Recommendation Report for Planning Permission

REF NO: P/15/12/

LOCATION: 10 Channel View
Pagham

PROPOSAL: Single storey extension & pitched tiled roofs over existing extension & existing detached garage

sheet 1 of 2

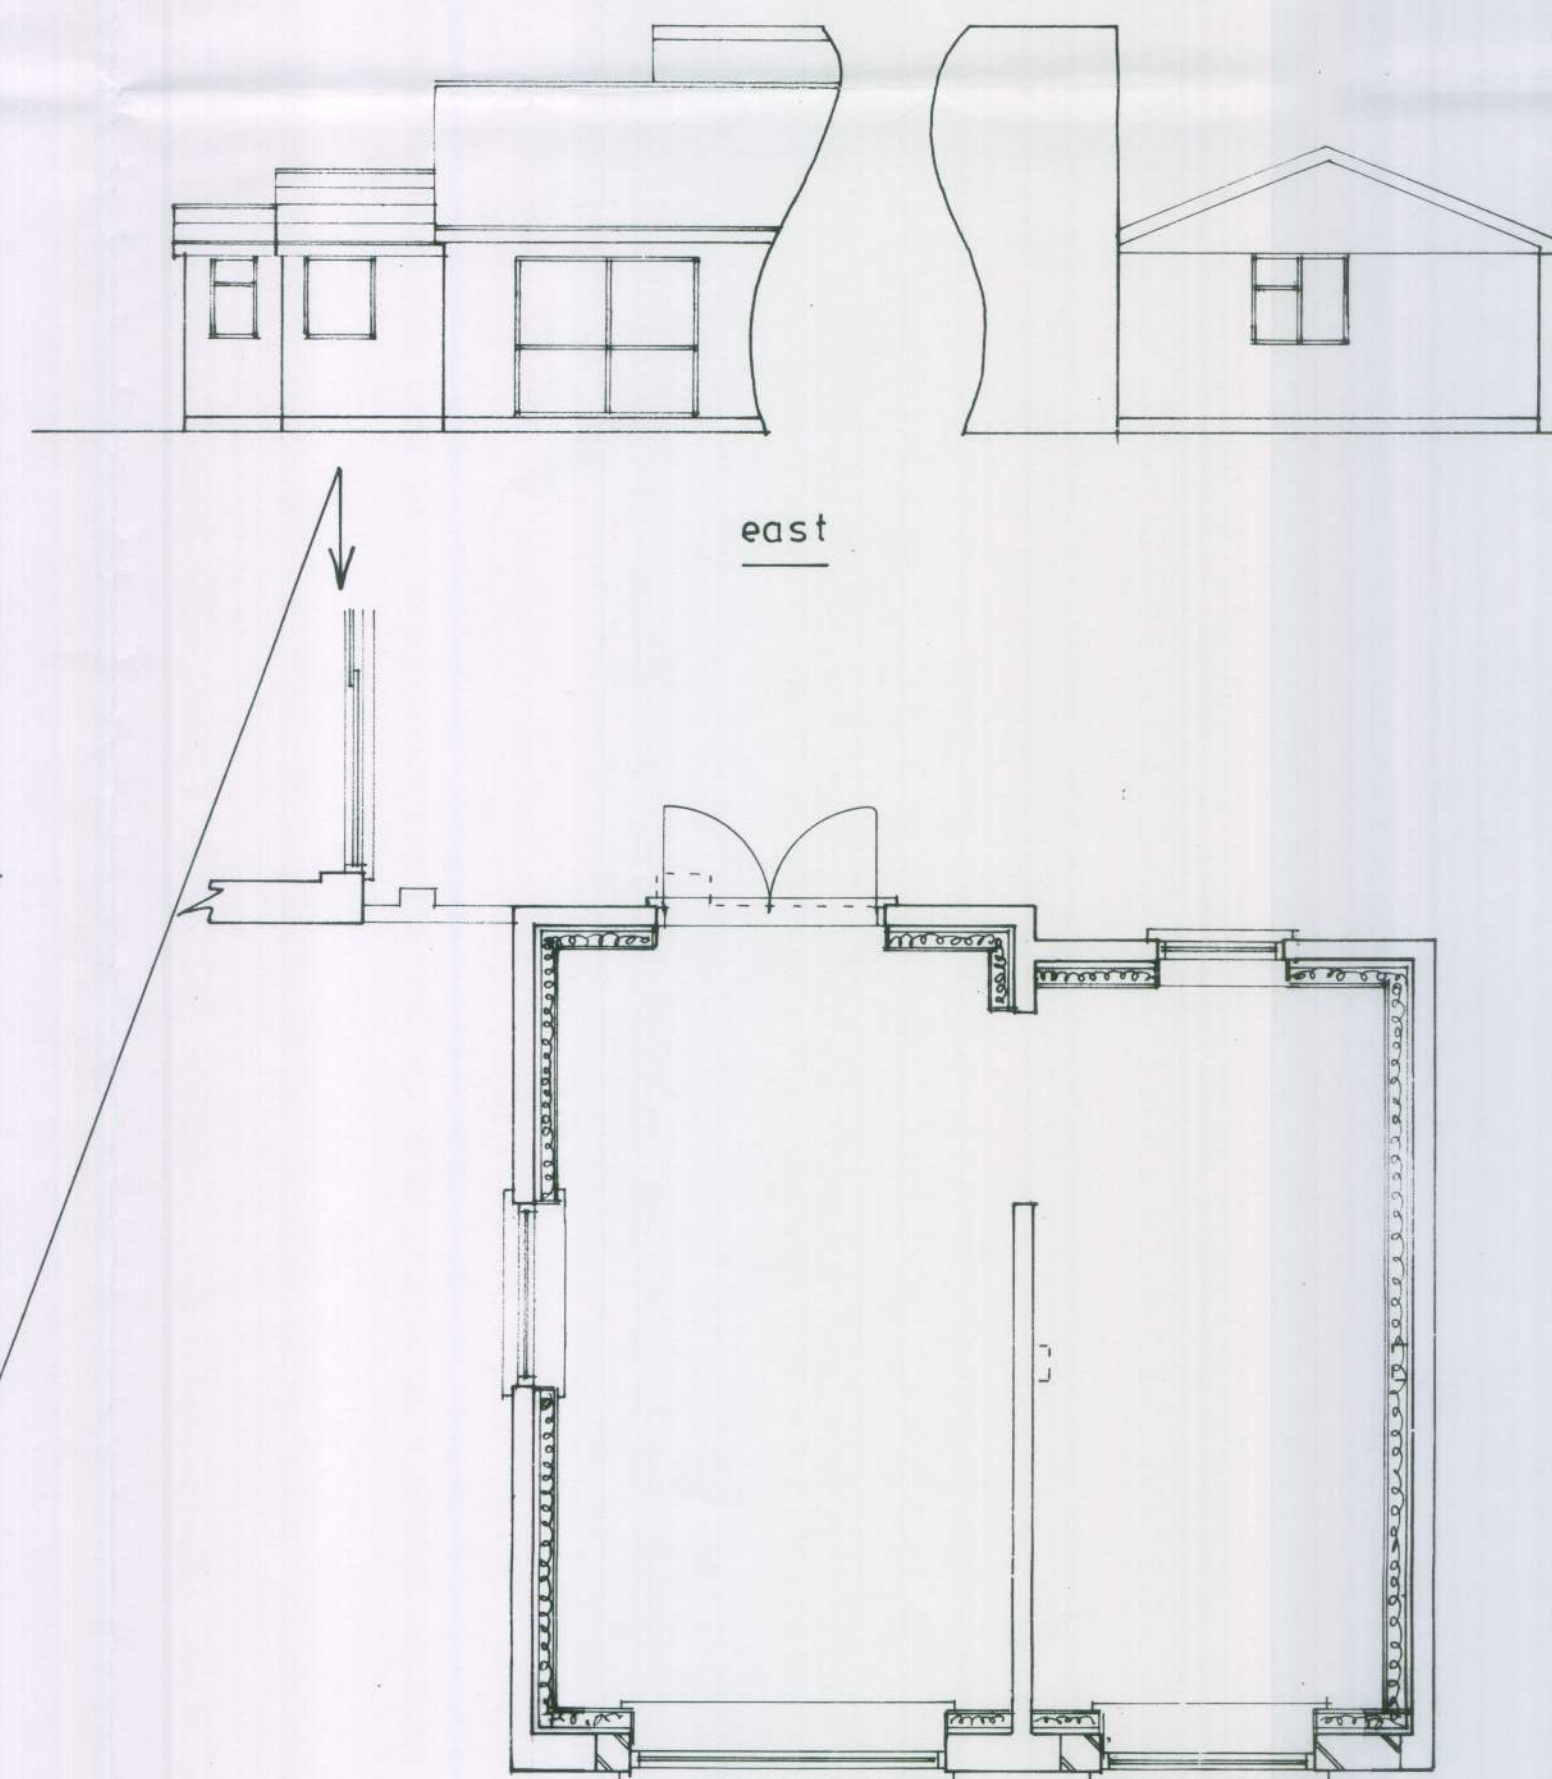
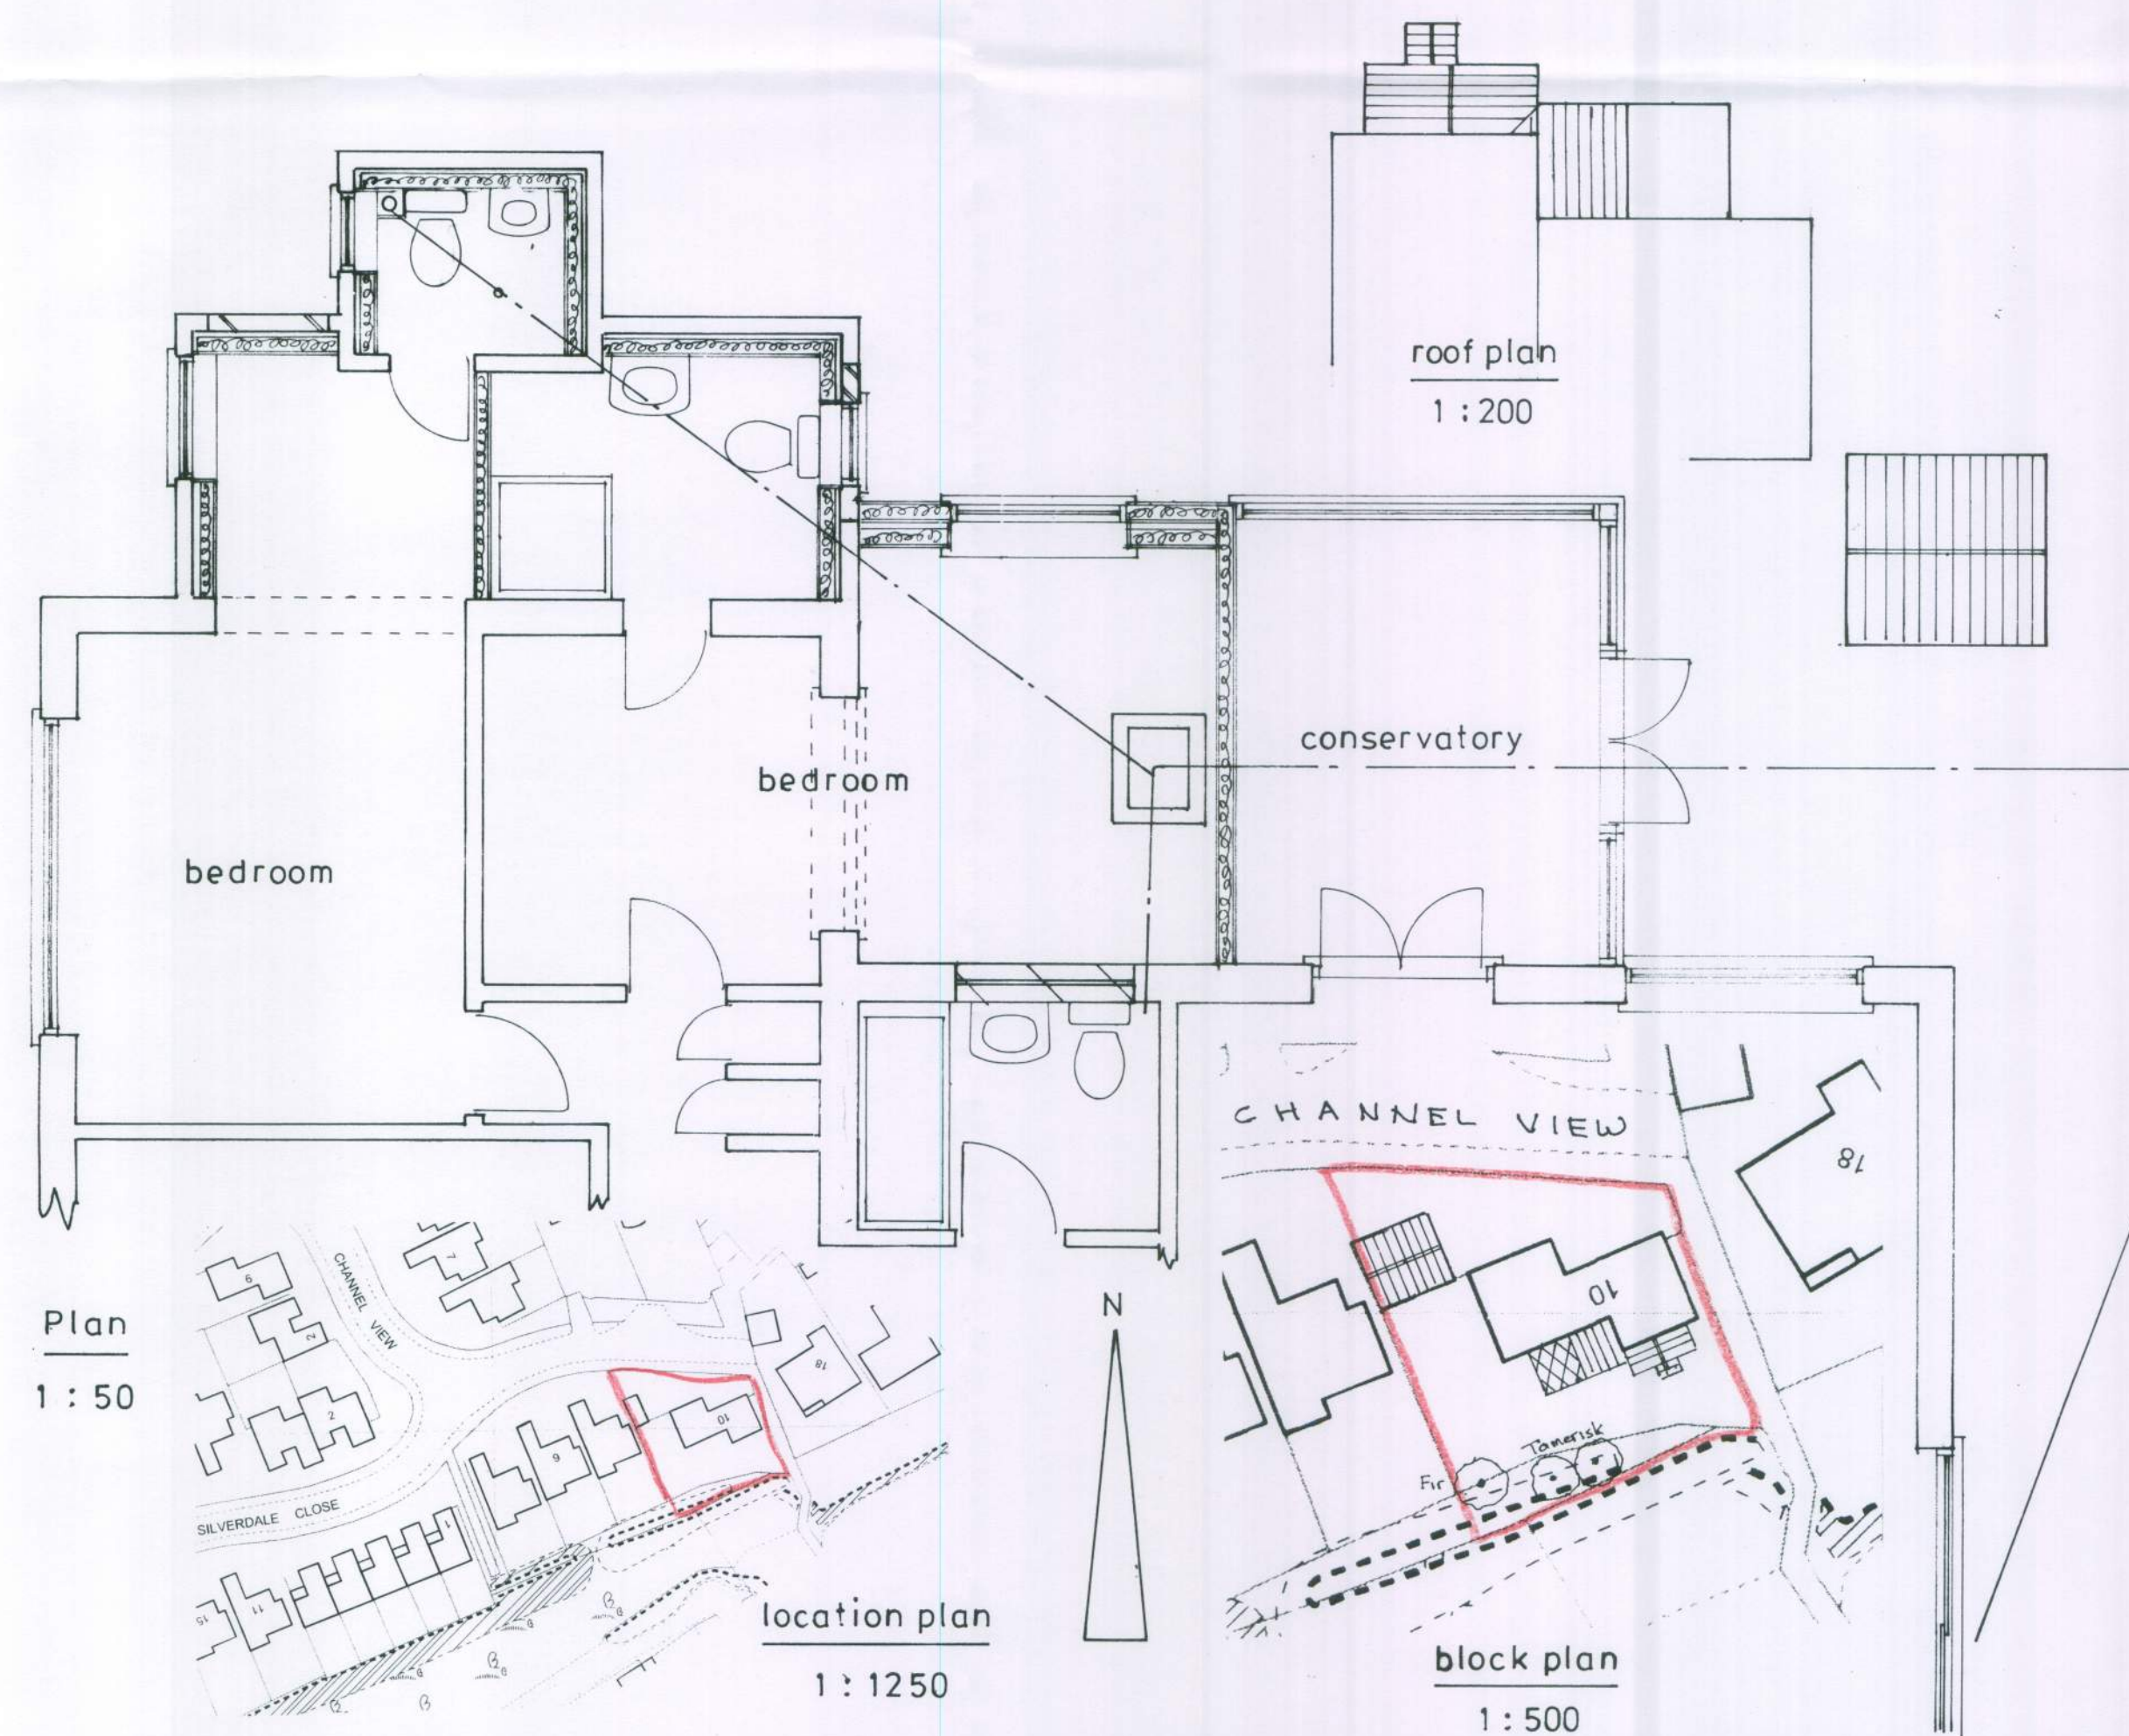
ARUN DISTRICT COUNCIL COASTAL ENGINEER- Referring to the current flood zone map, it would seem, contrary to the FRA, that the property is not within flood zones 2 or 3. The property is some 35 metres landward of the flood zone and sits behind a low defensive bank. Whilst the flood proofing measures proposed in the FRA are therefore not strictly necessary, we would not suggest that they be omitted. However, you might like to consider whether or not the the 500mm high external waterproof render band detracts from the street scene.

The proposed extension would measure approximately 2.6m in width, 3.1m in depth, and would have a lean-to roof reaching a maximum height of approximately 3.1m. The proposal will not extend beyond the existing rear building line. It is considered that the scale, siting and design of the proposed extension is such that it would be in keeping with the existing dwelling and as such is not considered to have a significant impact on the visual amenities of the locality.

The proposed pitched roofs on two small rear extensions will not have a negative impact on the character of the building and is considered acceptable.

The proposal also includes the conversion of the existing detached garage. The proposal to replace the existing roller doors with two windows is considered to be visually appropriate, and will not result in an increase in overlooking as there are no properties within close proximity to the north. However, the the proposal will result in the loss of two car park spaces. However, it is considered that the property has an existing hard standing capable of accommodating two cars comfortably, and in the absence of parking restrictions on the surrounding highway it is not considered that the loss of a parking space would be detrimental to the amenity of the area.

- The external waterproof render band is on the southern facade and should not affect the street scene.

sheet 2 of 2

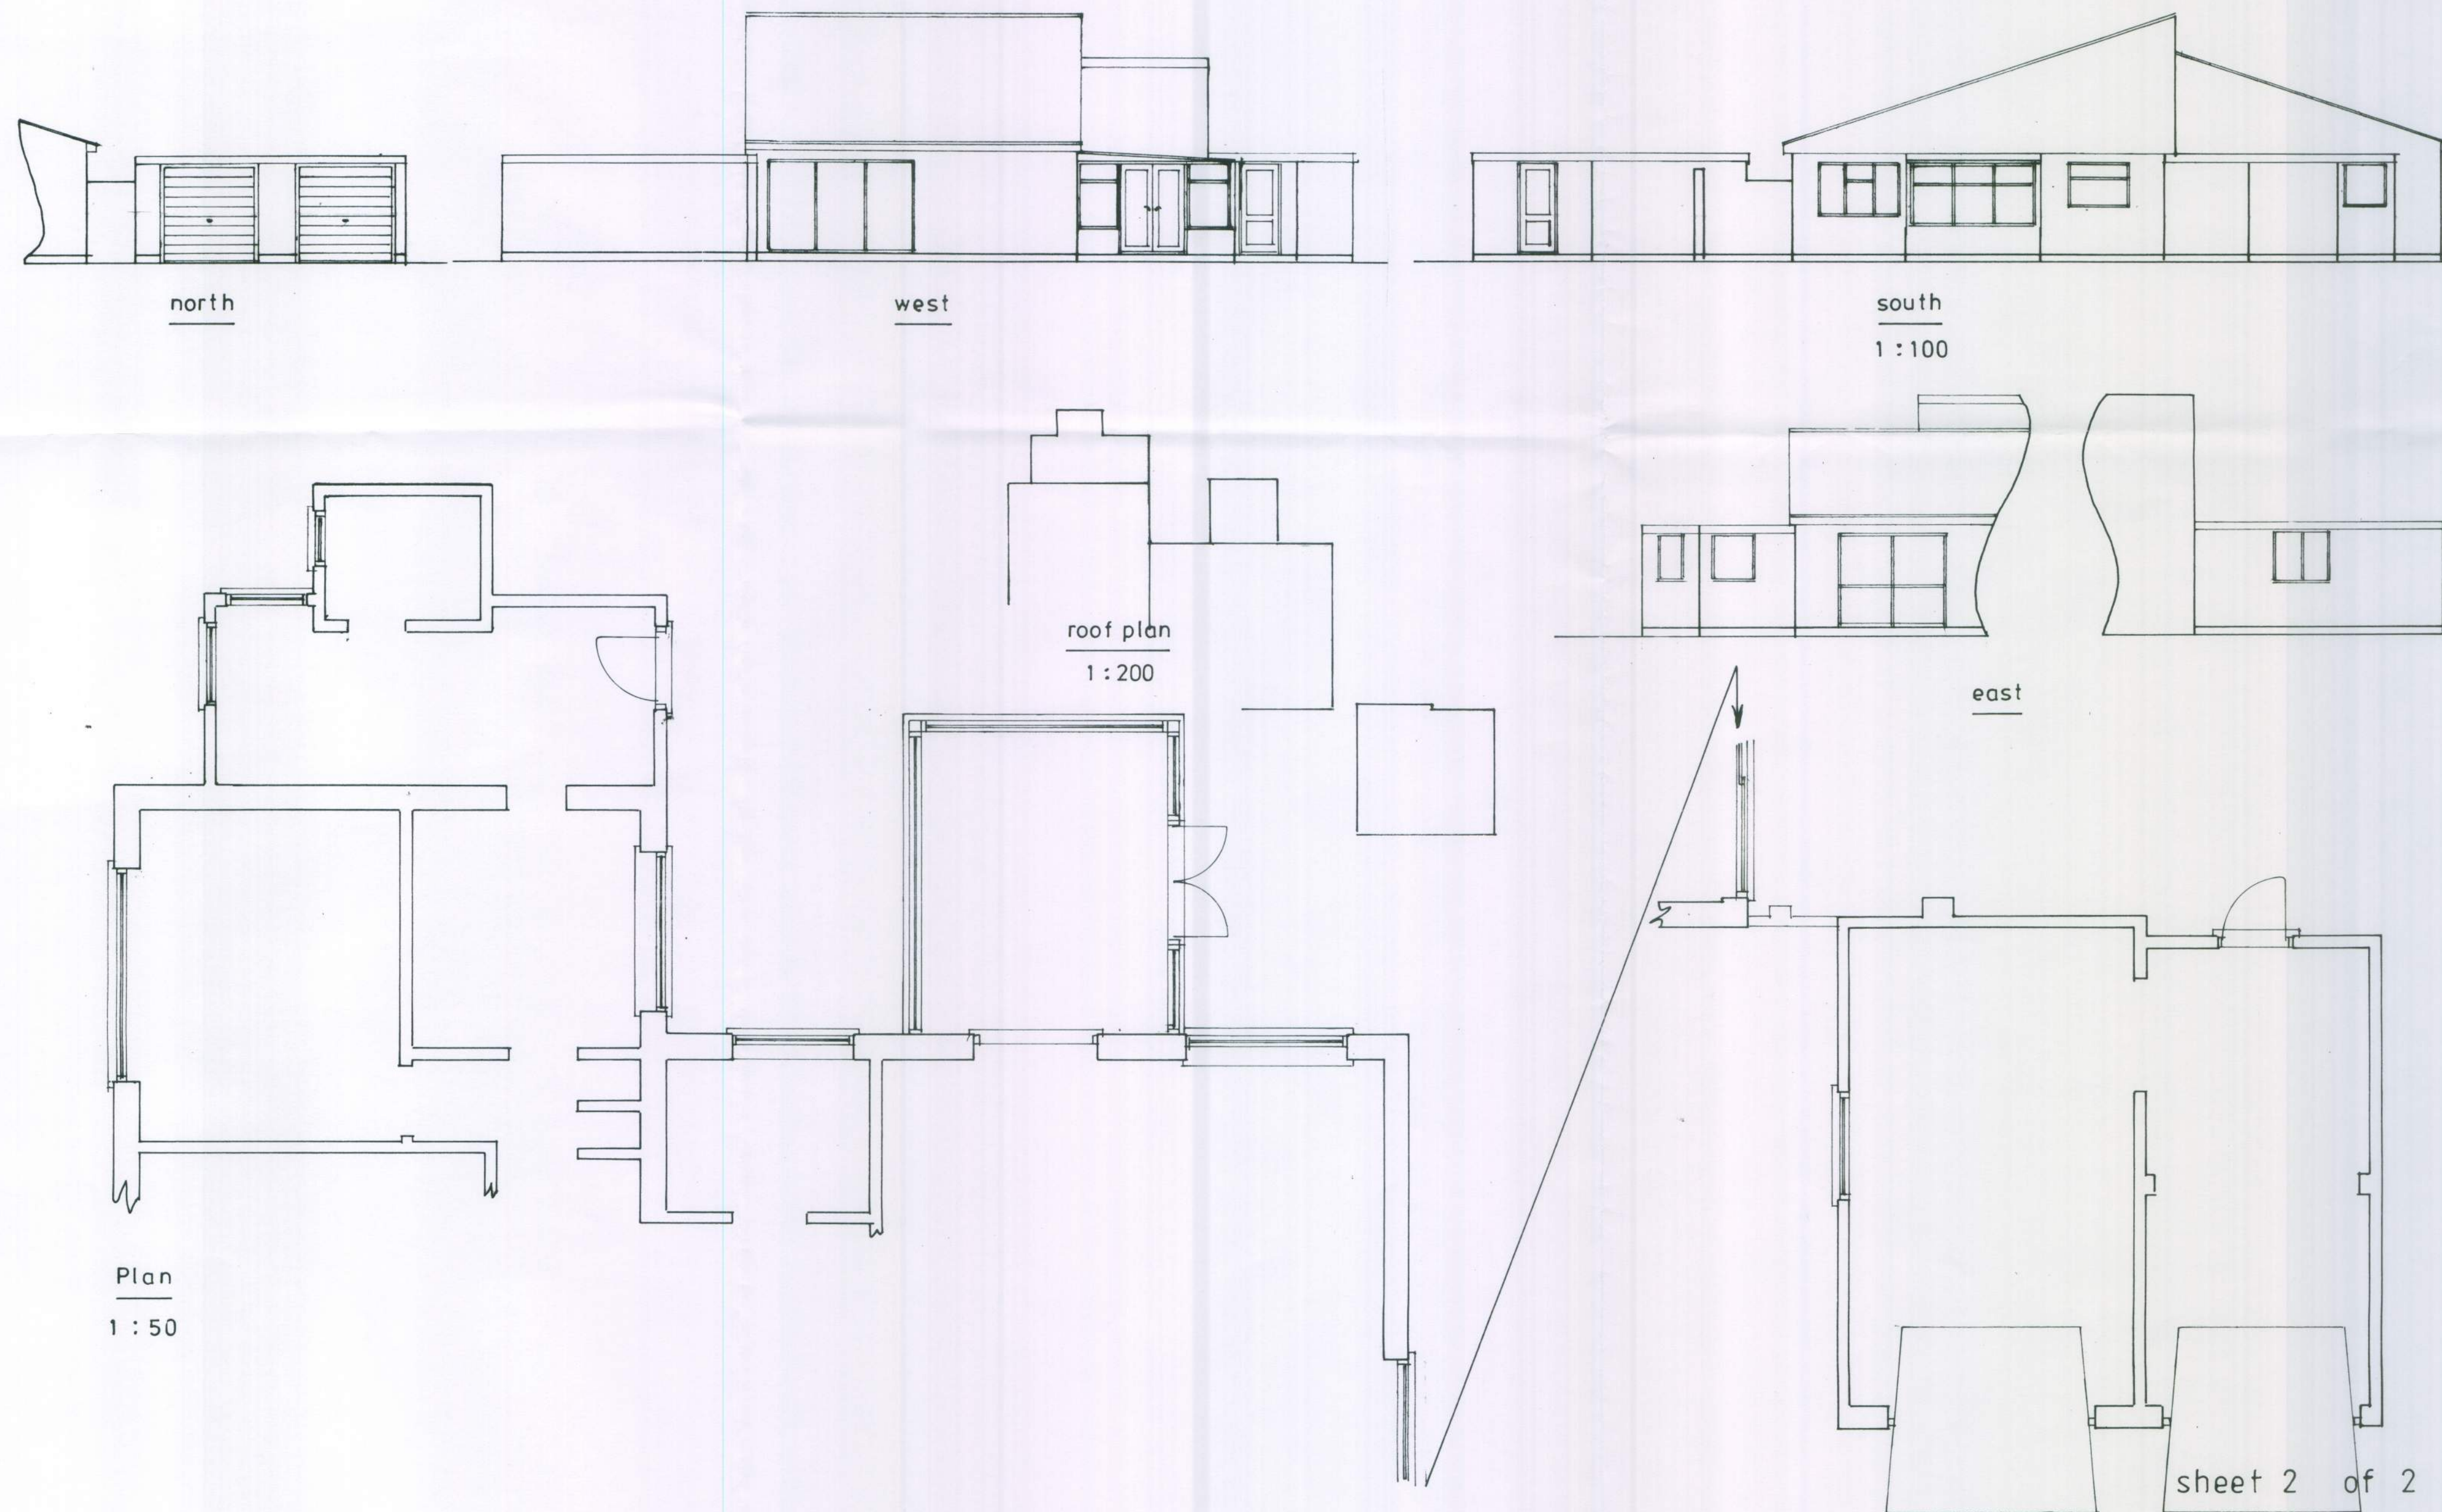
The proposal is not to construct a second storey but to add pitched roofs where there are existing flat roofs. On the garage, at the apex the proposed pitch roof would be 3.7 metres tall. This is not sufficiently tall to accommodate a second storey. Comments expressing concern over strain on foundations would be considered under Building Regulations Application.
